From: Simon Davis
Sent: 08 December 2021 12:50
To: 'Tilly Whishaw' [REDACTED]
Cc: Isabelle Renn [REDACTED] Craige Burden [REDACTED] Roger Spencer
<Roger.Spencer@arun.gov.uk>
Subject: RE: Planning Consultation on: Y/163/21/DOC Land at Street Buildings

Isabelle has forwarded me the comments from Laura regarding the application to discharge condition 12 at North End Road. For clarify condition 12 is as follows:

Engineers Comments Regarding Condition 12

Proposed Drainage Design Layout Sheets

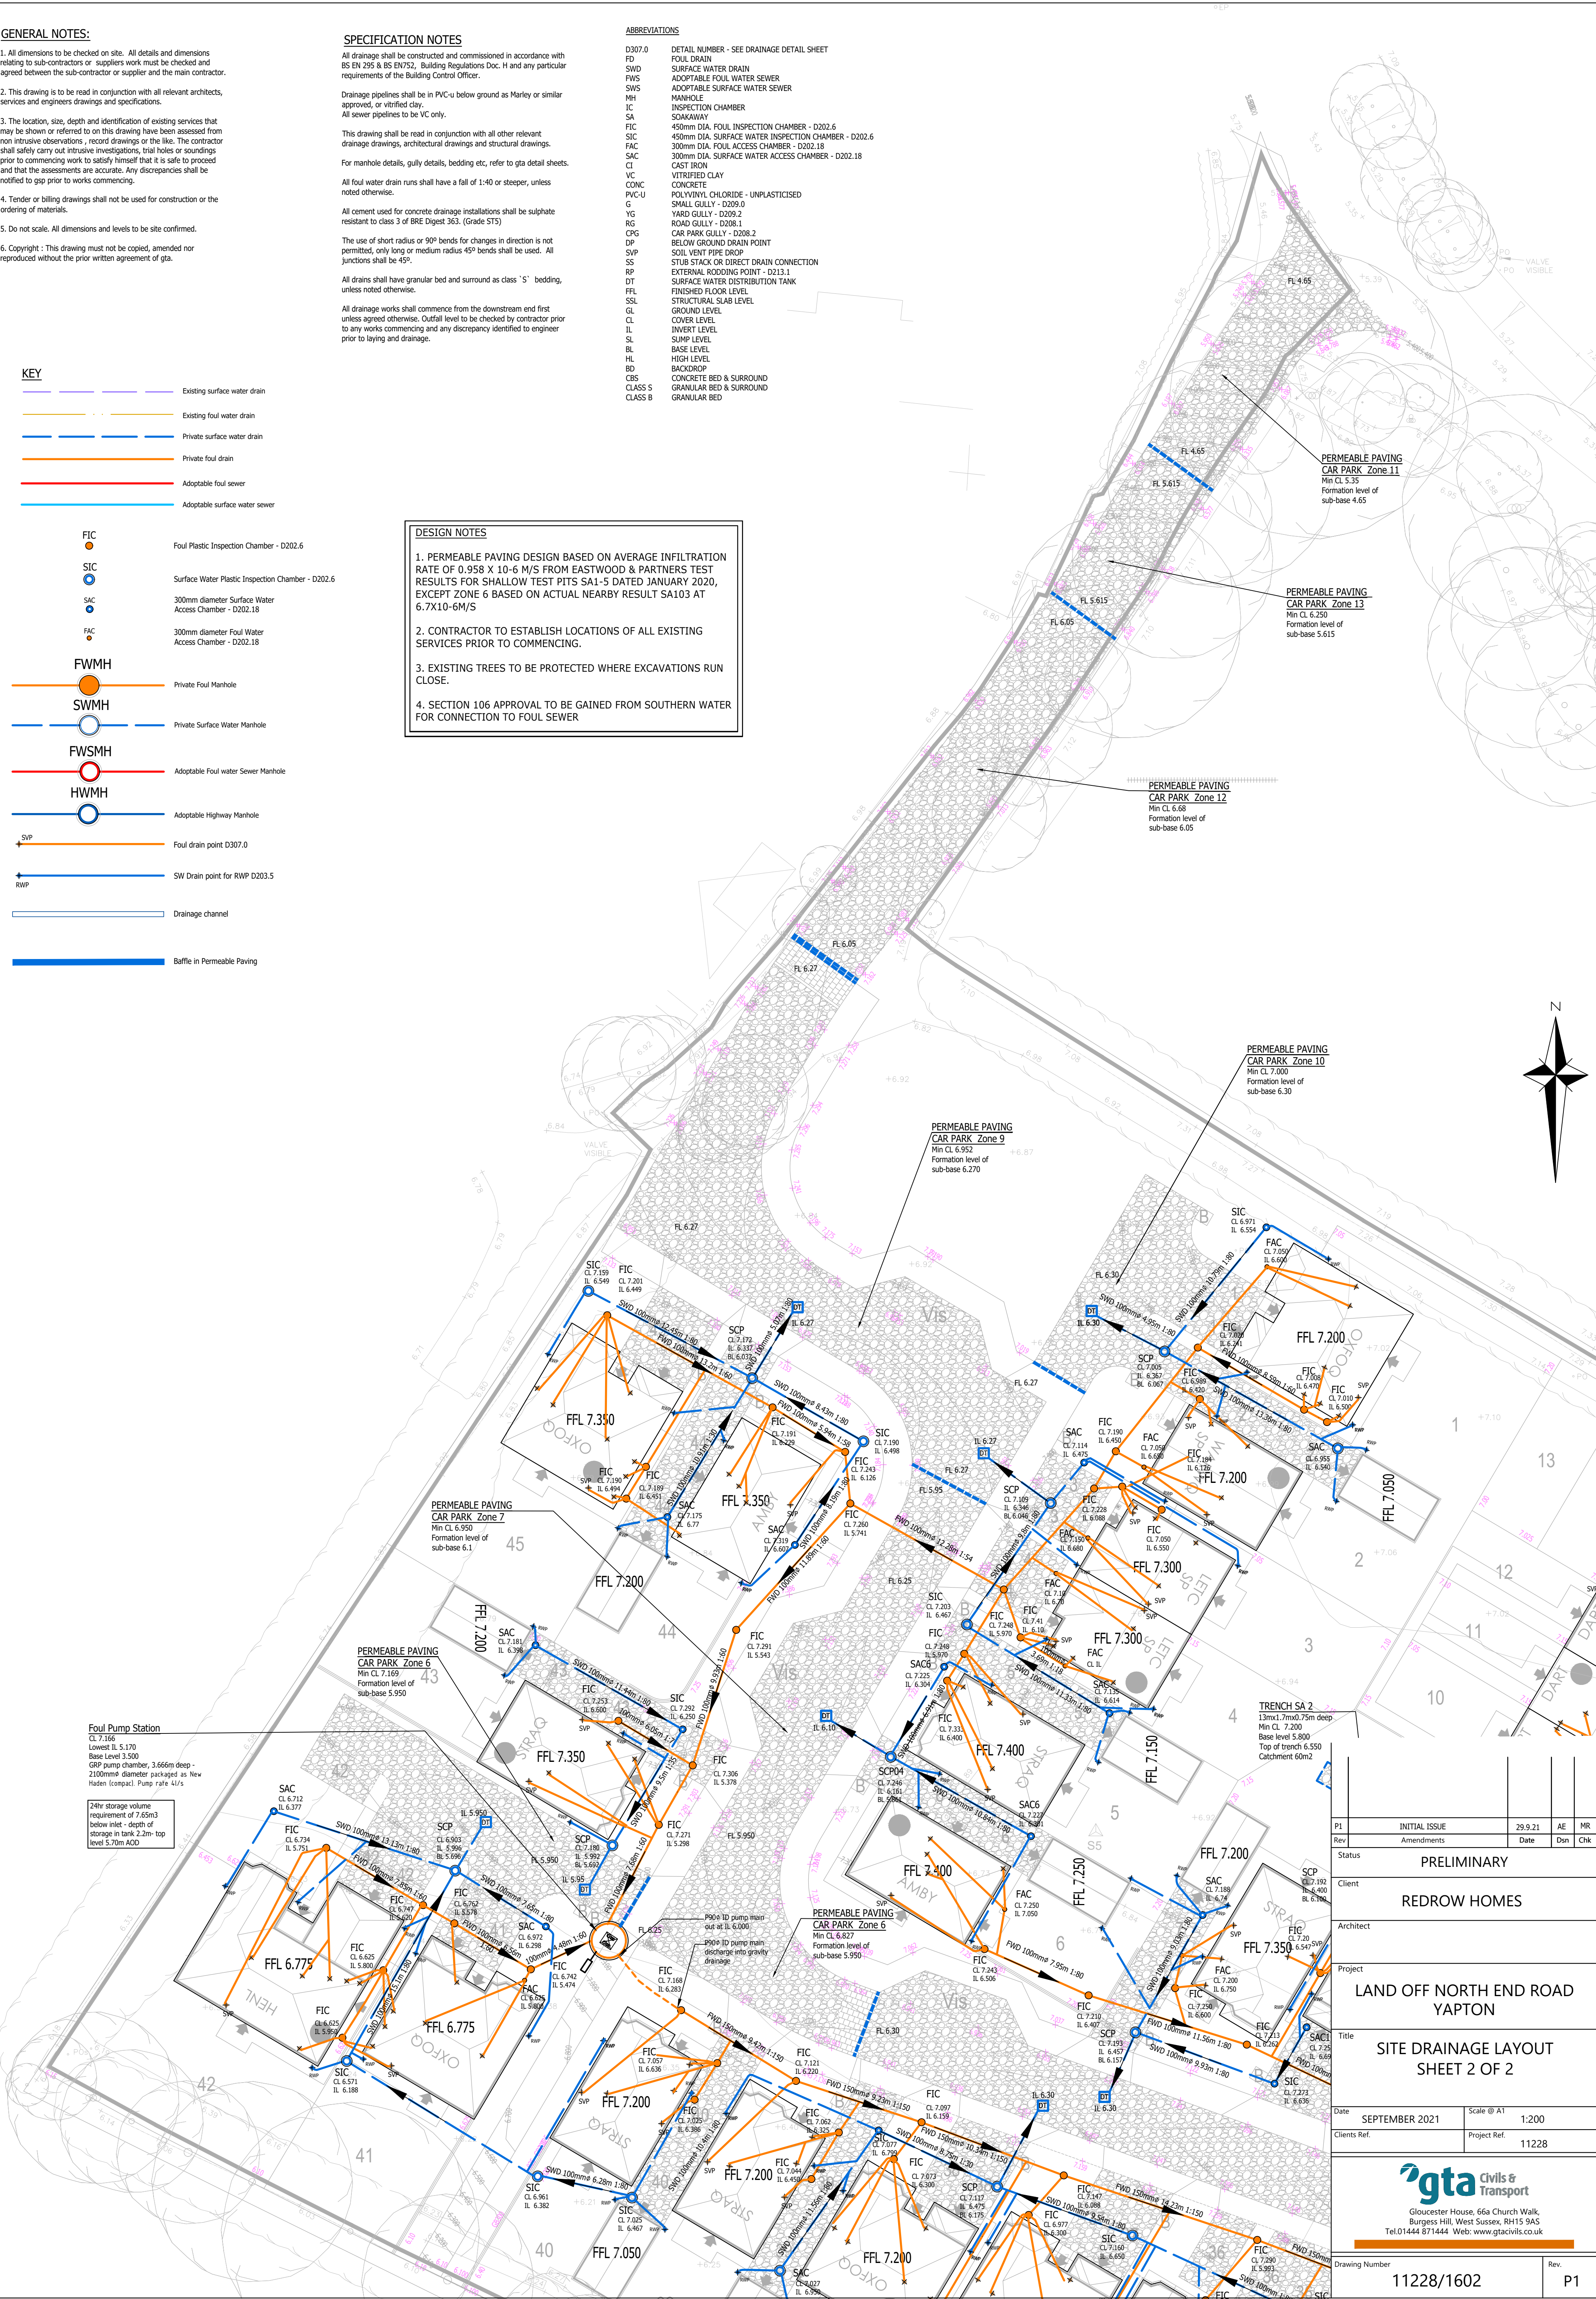
1. Construction detail drawings must be supplied.
2. Worst case infiltration rates from nearest adjacent test locations should be used in design, and not average site wide figures.
3. It is unclear if urban creep has been applied.
4. Inlets to infiltrating structures must be located above the 1 in 10 year plus 40% climate change event water levels.
5. Finish and formation levels must be labelled on plan.
6. Cap volume depths should be applied to calculations.
7. The permeable paving zone 9 area has an infiltration blanket shown in calculations, yet this is not shown on plans.
8. A safety factor of 2 has been applied to all calculations. This is not compliant with our checklist.
